From: [REDACTED]
To: [A303 Sparkford to Ilchester](#)
Subject: SPIL-AFP052
Date: 16 September 2020 00:25:36

REQUEST BY THE SECRETARY OF STATE FOR COMMENTS FROM ALL INTERESTED PARTIES

Gason Lane/Vale Lane crossing

| Drawing Title FIGURE 2.4 RIGHTS OF WAY AND ACCESS PLANS - SHEET 2 OF 4 REGULATION 5(2)(k) and 5(2)(o) | | | | | |

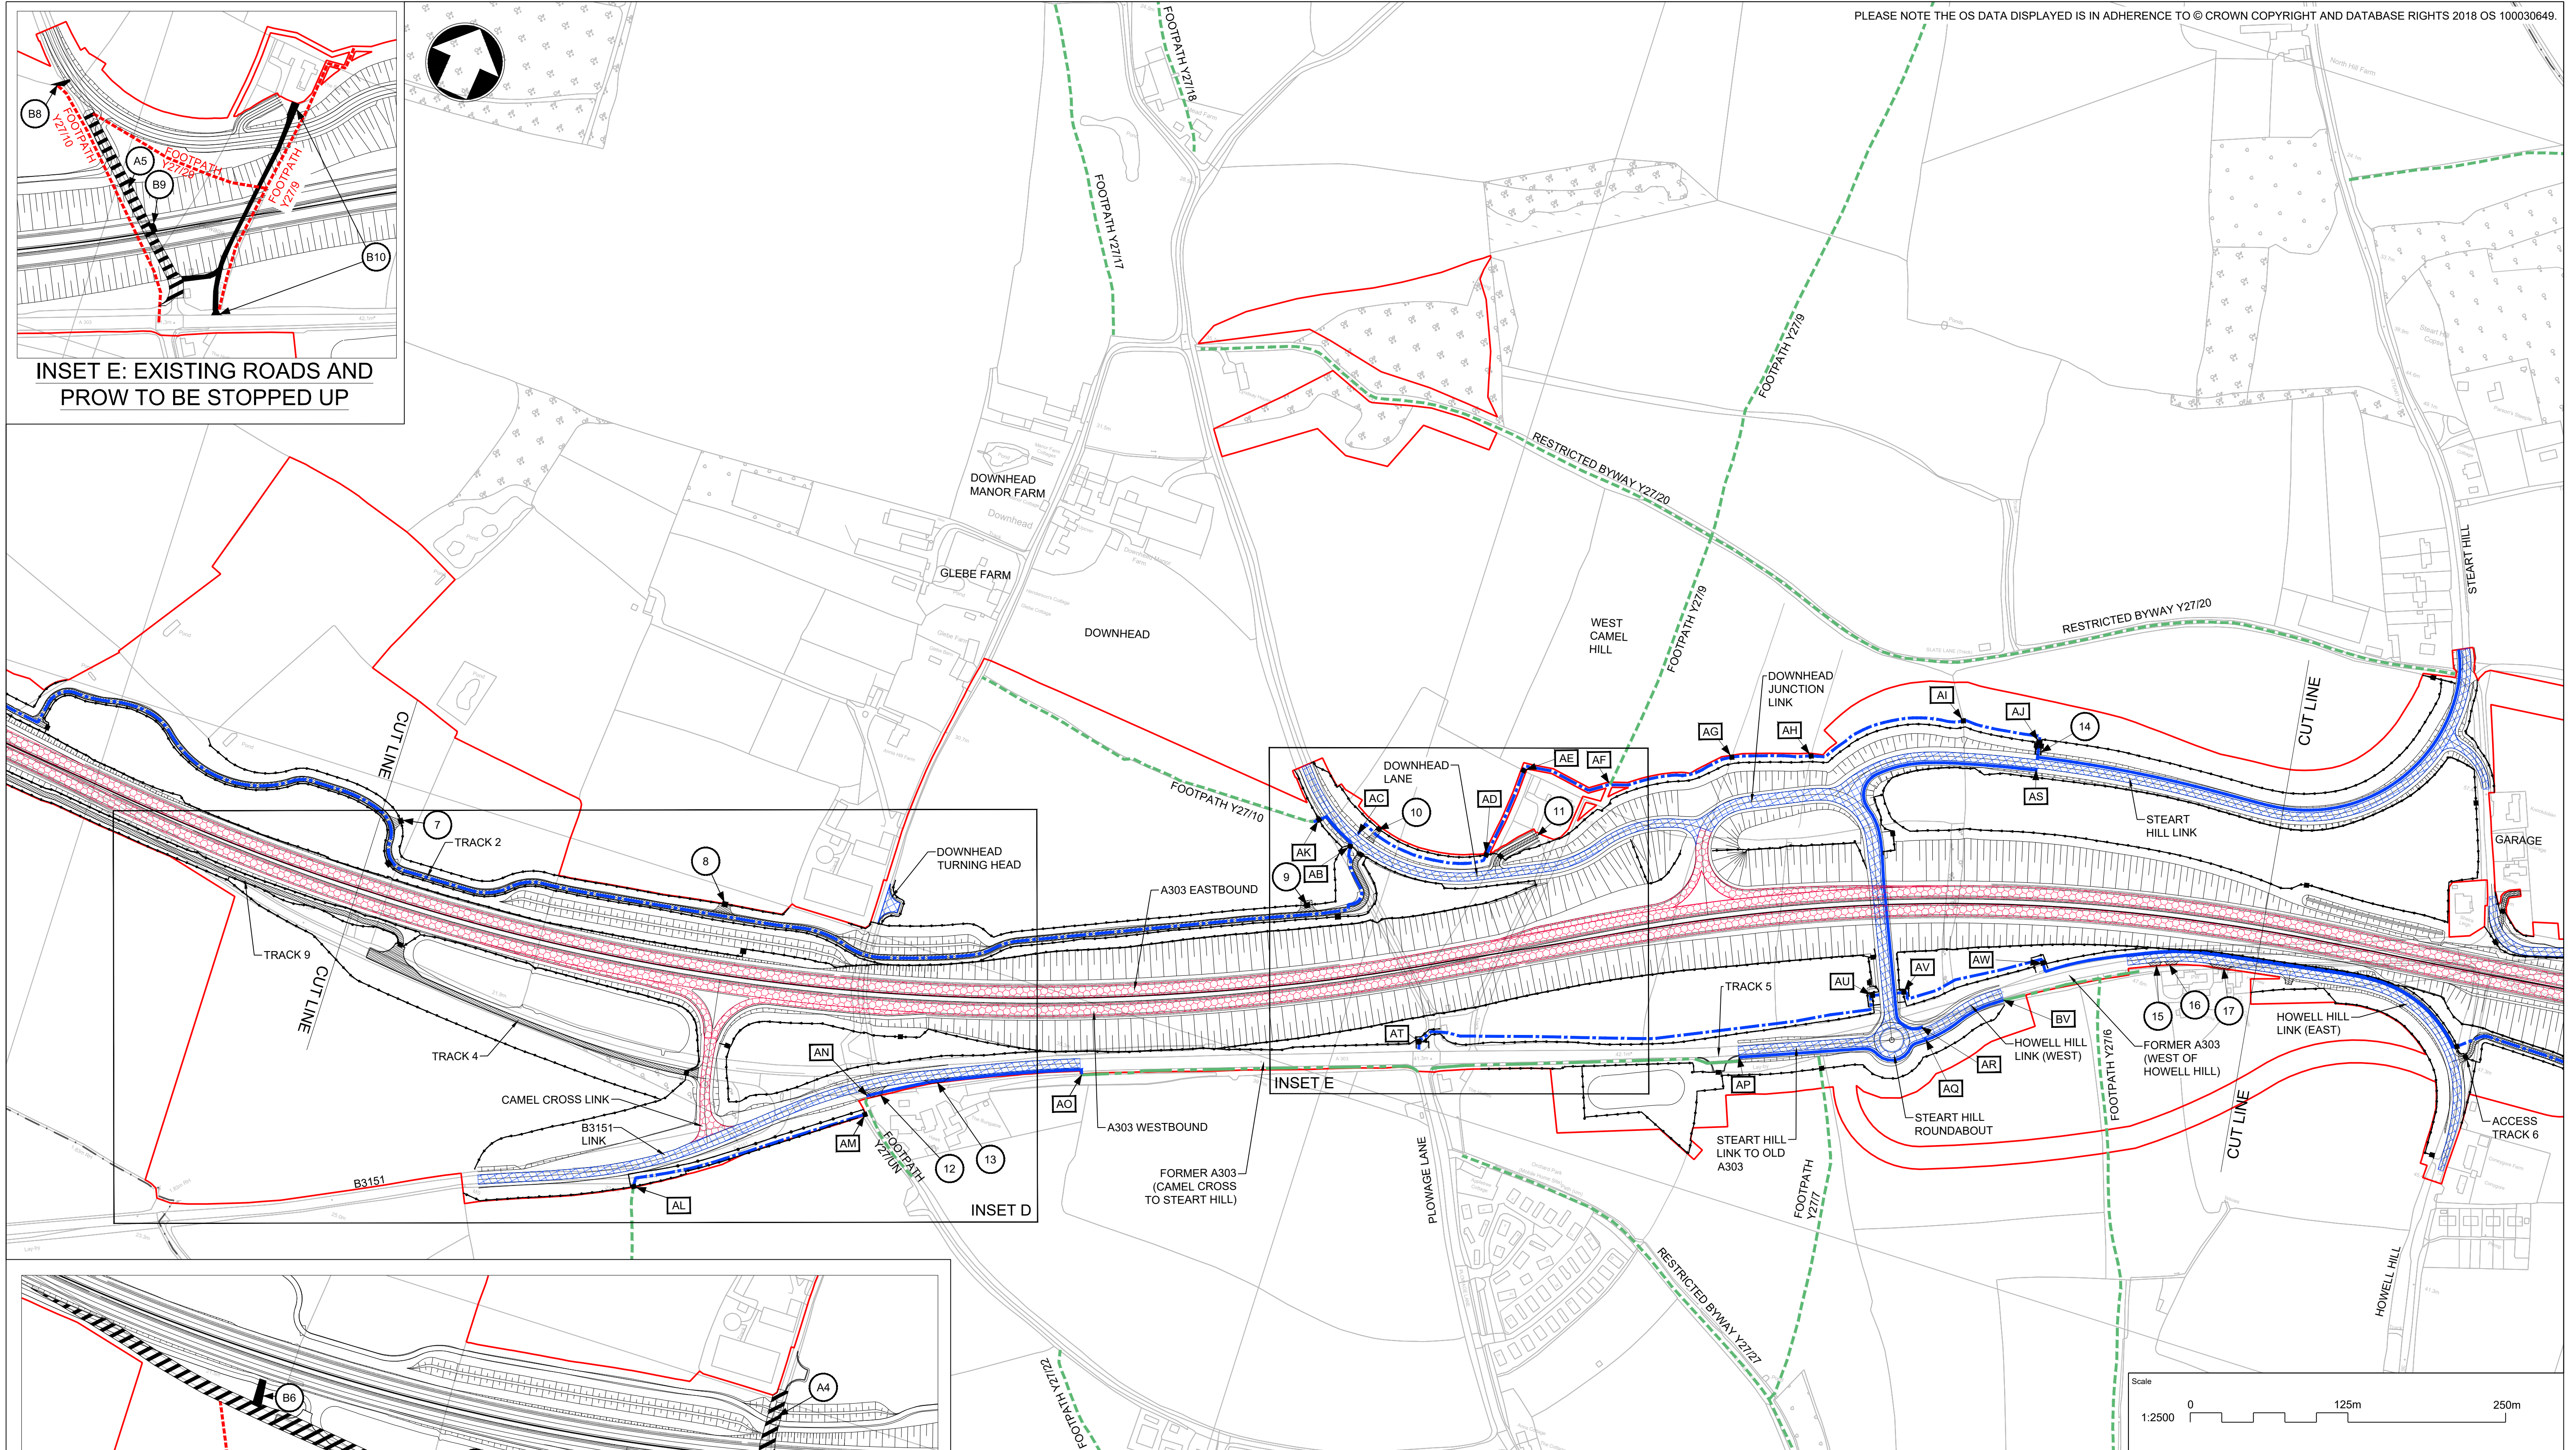
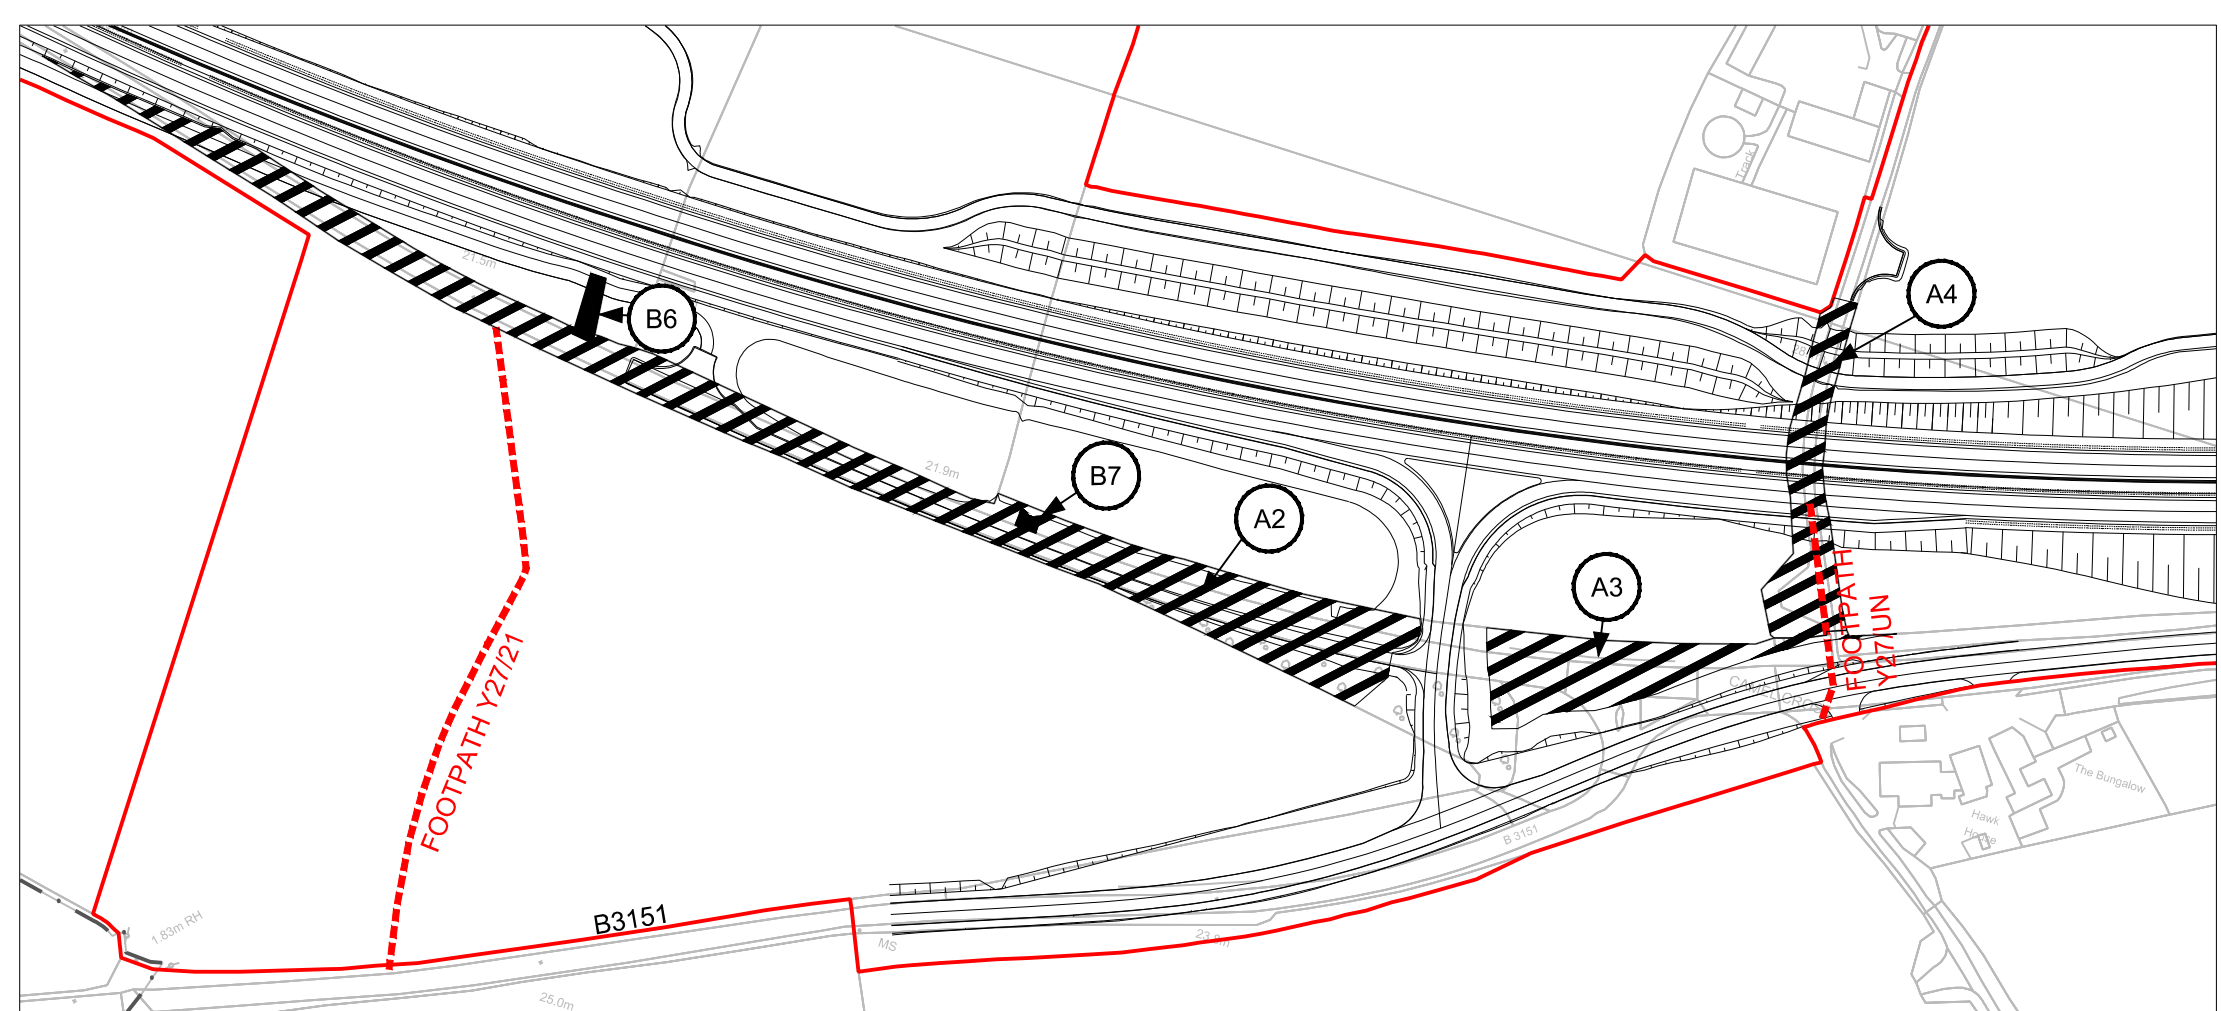
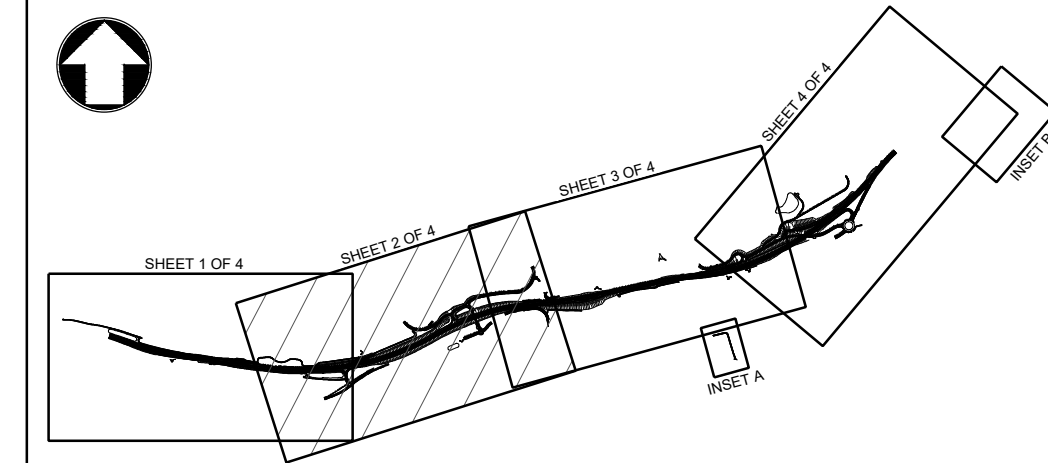
There are 10 properties in the parish of Queen Camel that are located north of the A303 in Vale Lane (a no through road).

Vale Lane directly crosses the A303 on to Gason Lane and it is a 10 minute walk from Vale Lane, down Gason Lane to the village centre (Queen Camel) and all the amenities that the village provides.

If Gason Lane is stopped off with no access to Vale Lane, the only way to cross the A303 by foot or by bicycle will be the proposed route to Hazelgrove roundabout. This is a hazardous crossing to say the least.

The additional time (some 30 minutes) added to make this journey, and the extra effort needed to make it, is likely to discourage anyone from even bothering to do so, and would make a car the best option to "pop down the village". This will just result in adding further unnecessary traffic from Vale Lane on to the Hazelgrove roundabout simply to cross the road...

Highways England should provide for the properties/households in Vale Lane, access to Gason Lane (and the village) for non motorised users, either via an appropriate underpass or bridge.

The decision to stop off Gason Lane for local residents, I believe, is wrong and should be reviewed.
